Case Officer: Hannah Kersley
Reference: BN/37/22/T
Location: Land west of Green Acres, Lake Lane, Barnham, PO22 0AE
Proposal: Various works to various trees
Reasons given: To reduce influence over newly constructed dwelling

Project title Land at Lake Lane Barnham, West Sussex			
Drawing title Tree Retention and Protection Plan Tree Works Application			
Scale 1:250 @A1	Drawn GS Approved JJ	Date 16.03.2022	Revision 00
Drawing No LLD1532 / 01 CAD Filename LLD1532 / CAD			Revision 00

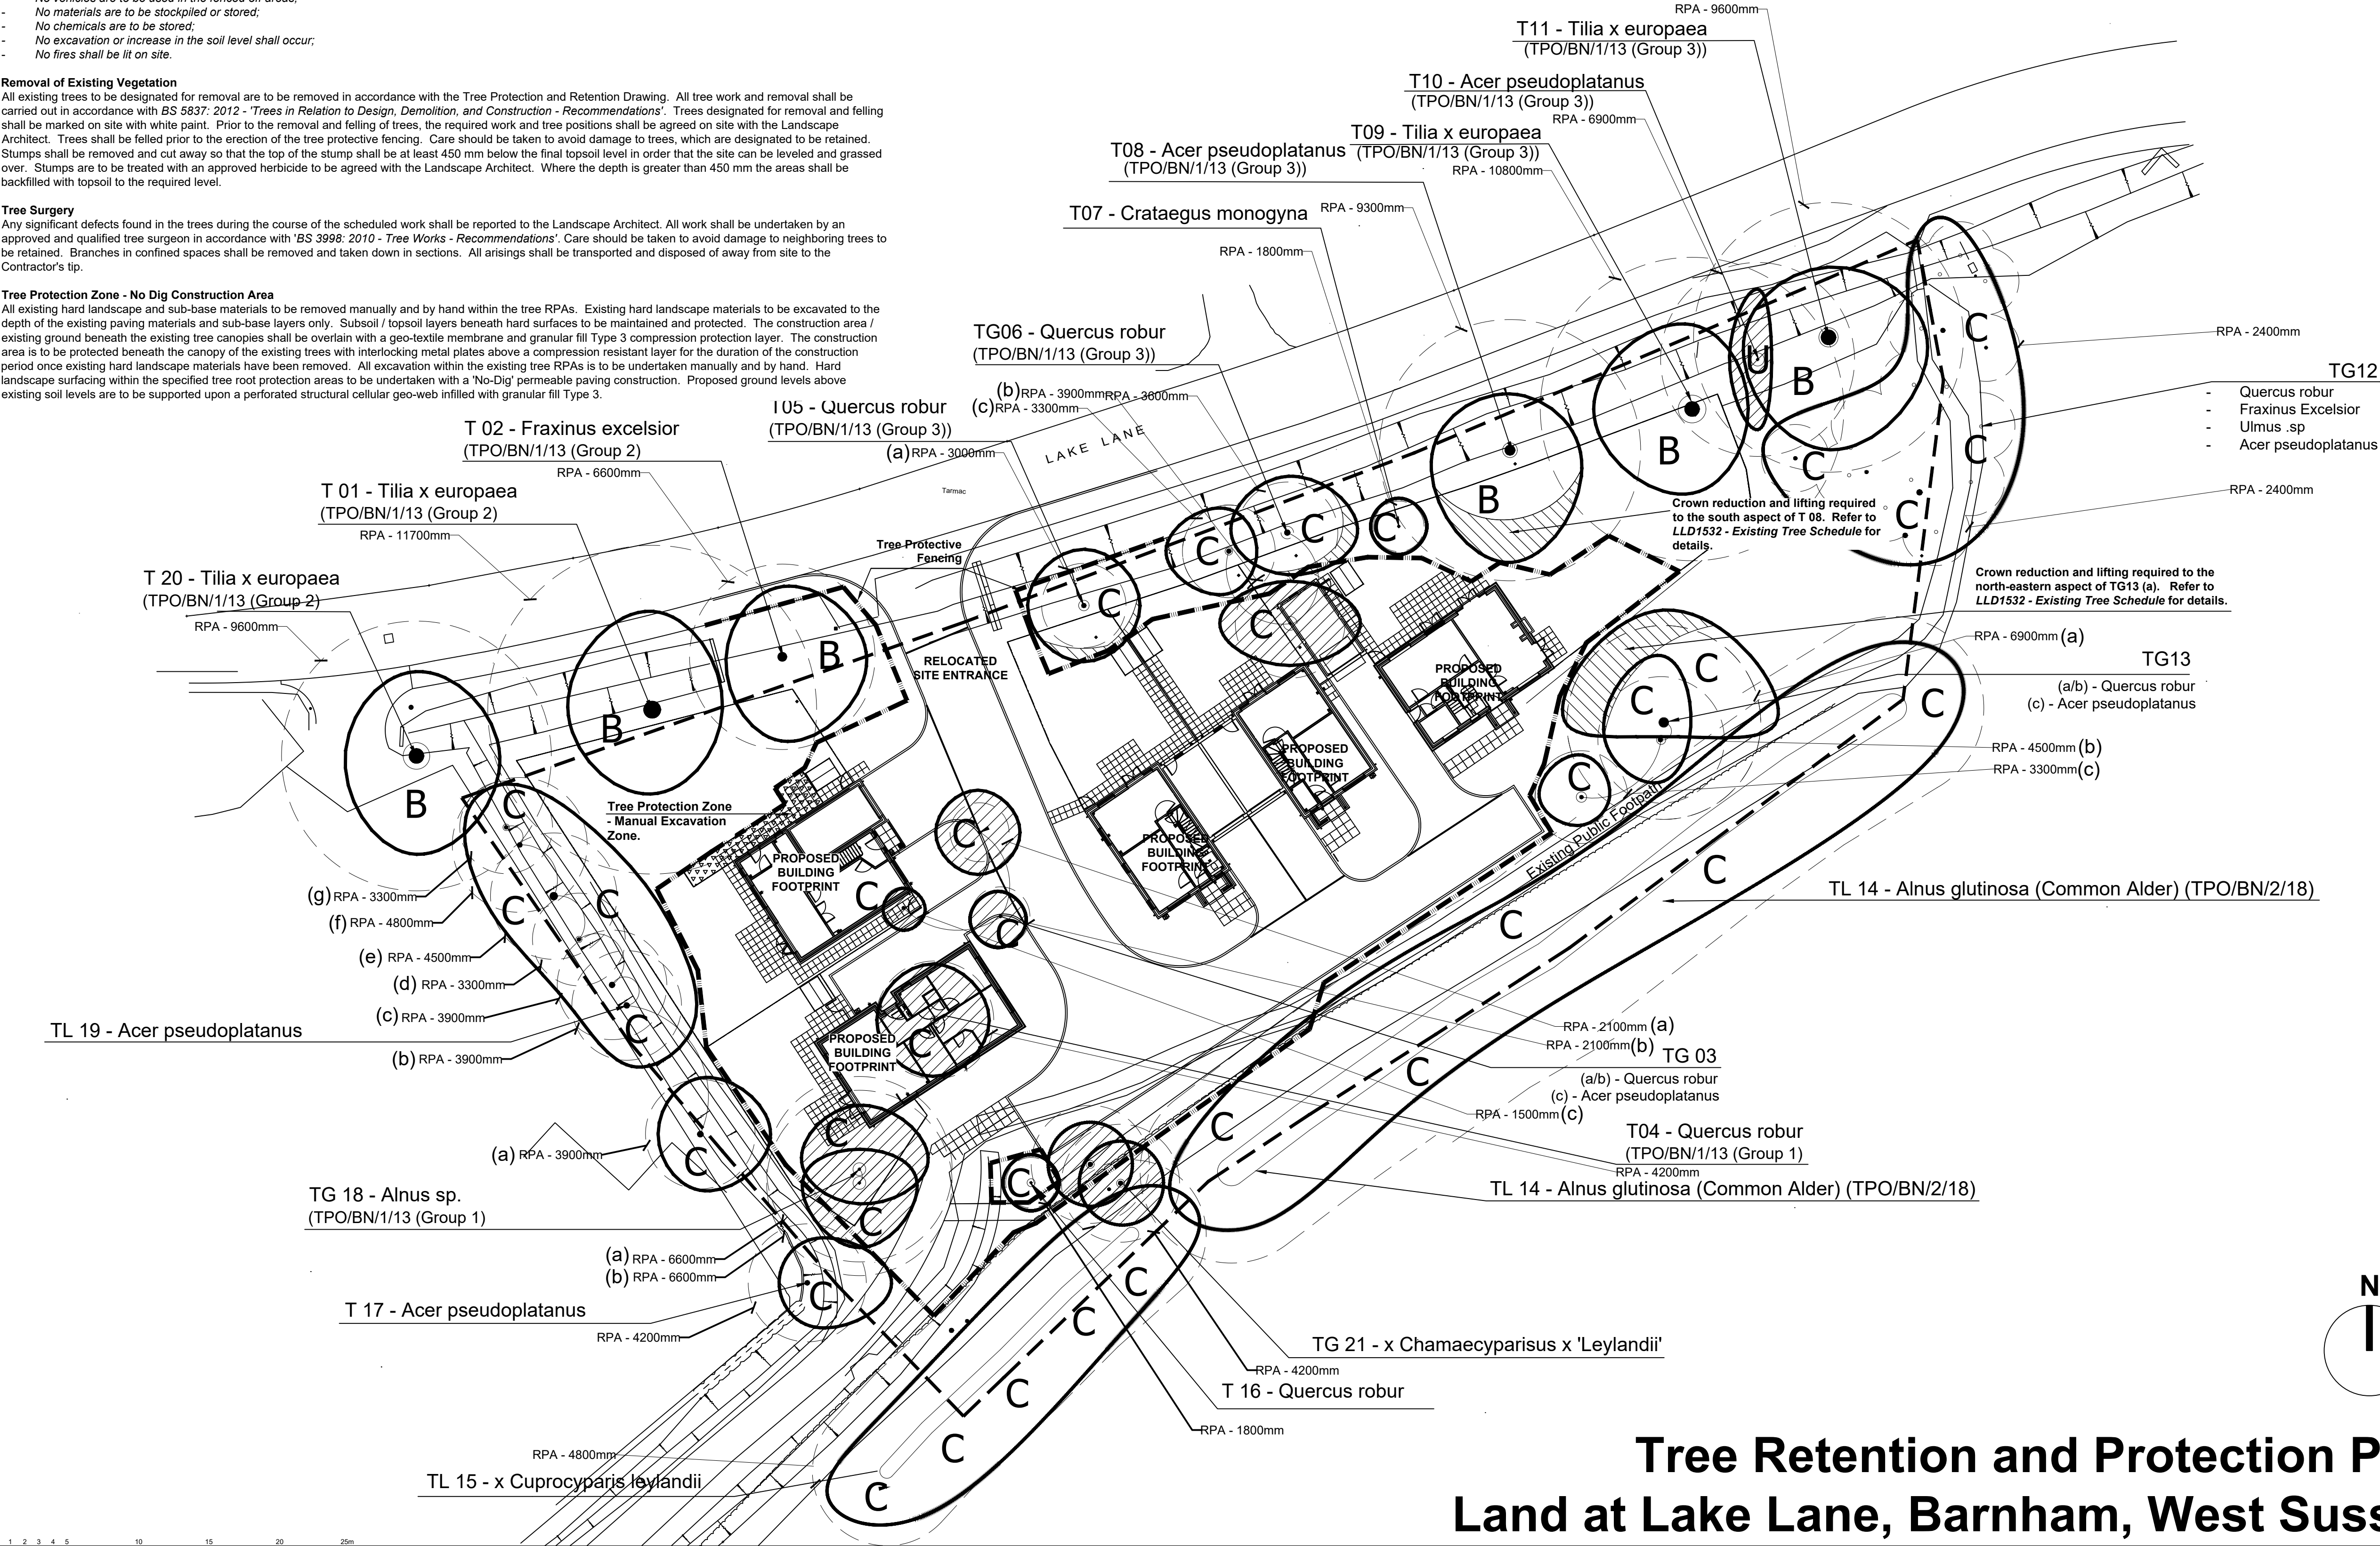
- Outwardly both trees appear to be in a fine physiological state and assumed to be so in the absence of any evidence provided to the contrary.
- The applicant/agent has submitted a tree survey and plan. Those are comprehensive and include detailed work specification with satisfactory reasons given for each item.

- The work proposed is justified on arboricultural grounds due to the proximity of branches to newly constructed dwelling and encroachment over garden area.
- A large wound is to be created near the base of T08 which is contrary to the requirements of BS3998:2010 Tree work – Recommendations. Retention of some length of the limb and subordinate branch structure would be preferable if practical to do so. It is vital that the work is undertaken to a high standard (position of final cuts) and at the right time, to minimise adverse effect on the tree's long-term vitality and visual amenity.

- I recommend **CONSENT** is granted subject to the following condition:

Part a) Where whole branches are to be removed and final cuts made close to the trunk or branch union they are to be made as shown in Figure 2 of BS3998:2010

Part b) Where branches are to be shortened back the final cuts are to be made at the correct angle shown in BS3998:2010 and adjacent to a live bud or lateral.

- For oak the optimum time to prune is during the late spring to summer period (May to August).
- For sycamore (which are also prone to bleeding from wounds) the optimum times to prune are during summer (June to August) and mid-winter (late-December to early-February).
